Harris Structural Design, PA

November 30, 2022

Concerning: Martinez Commercial Properties, LLC
308 Jarco Dr.
Fuquay-Varina, NC

content  
 RETAINING WALL DETAILS

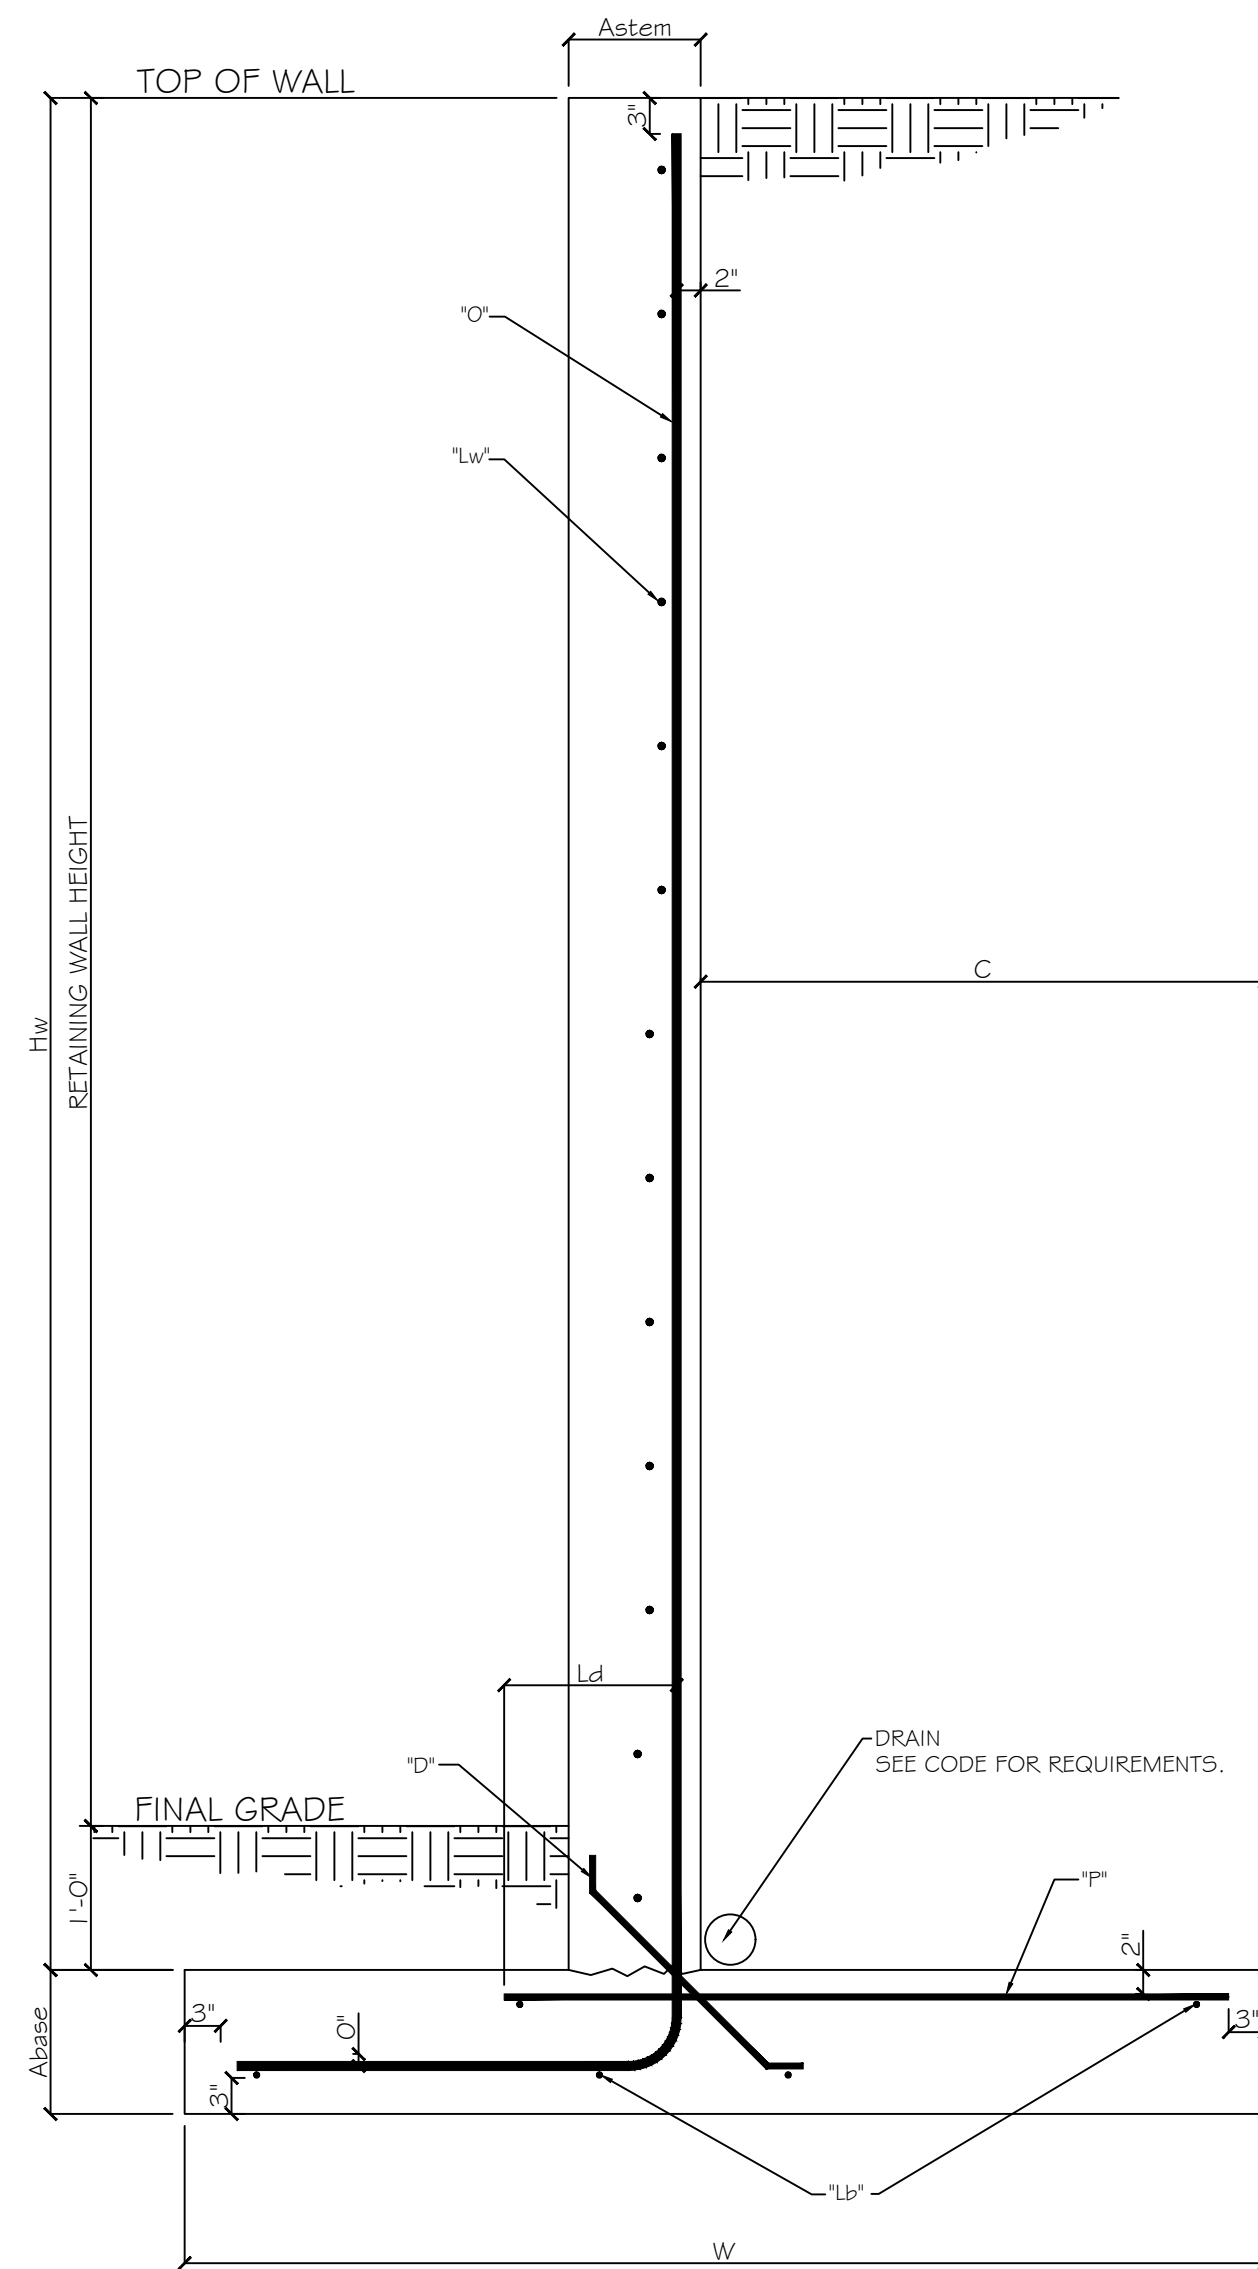
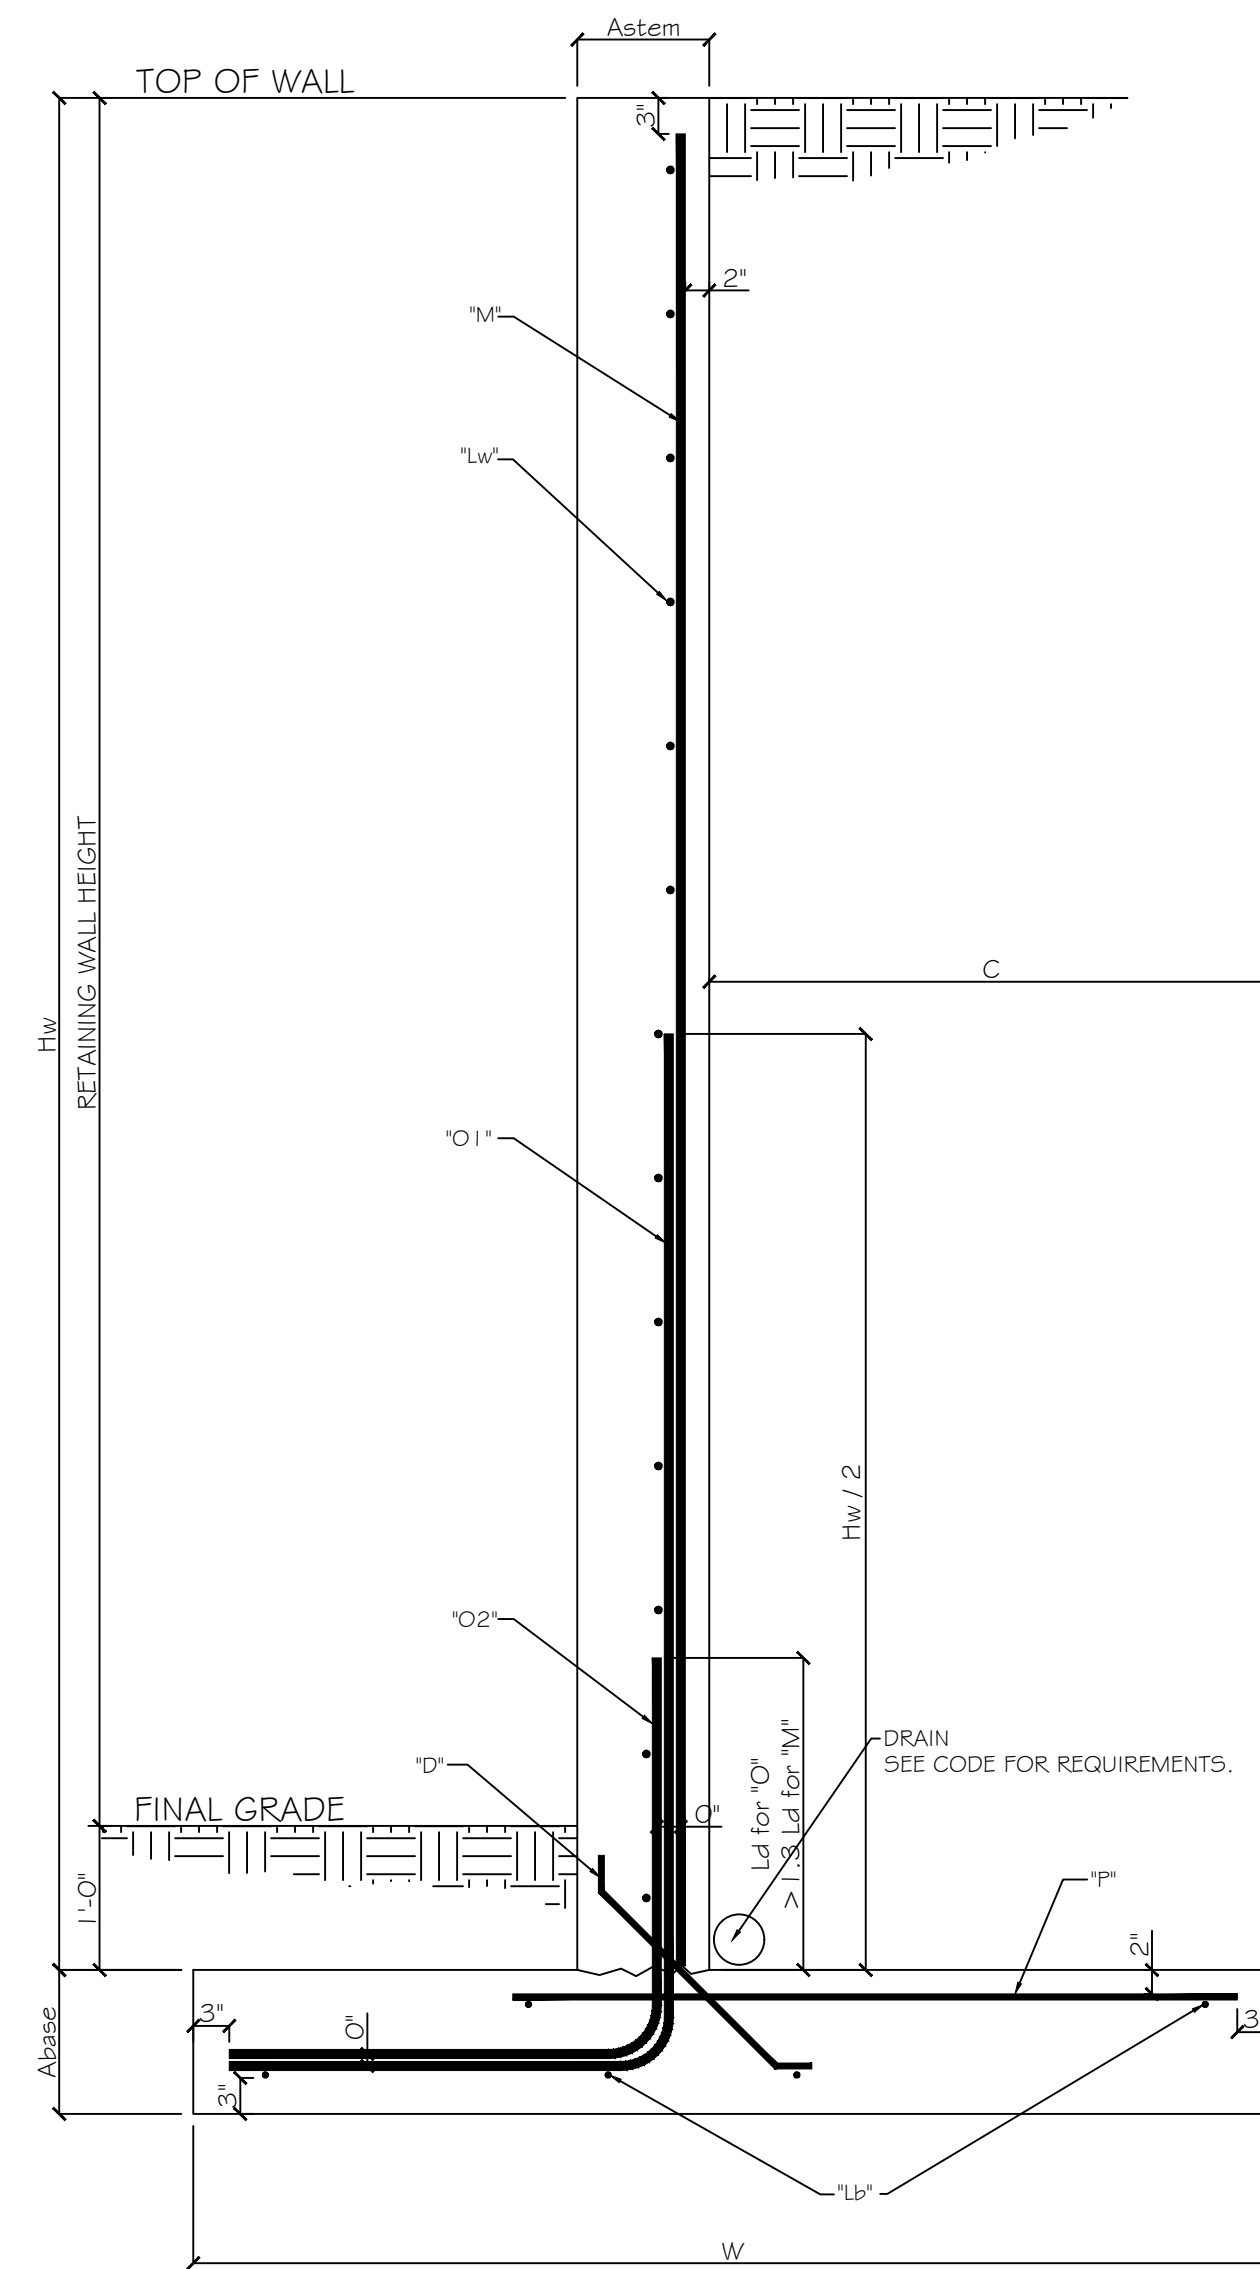
I have been asked by the contractor building the retaining walls shown on our plans if the drains that we show behind the retaining wall should penetrate the wall. With walls of this length, we recommend that the drain penetrates the wall at approximately 40' on center to ensure that water behind the wall properly drains and does not build up pressure.
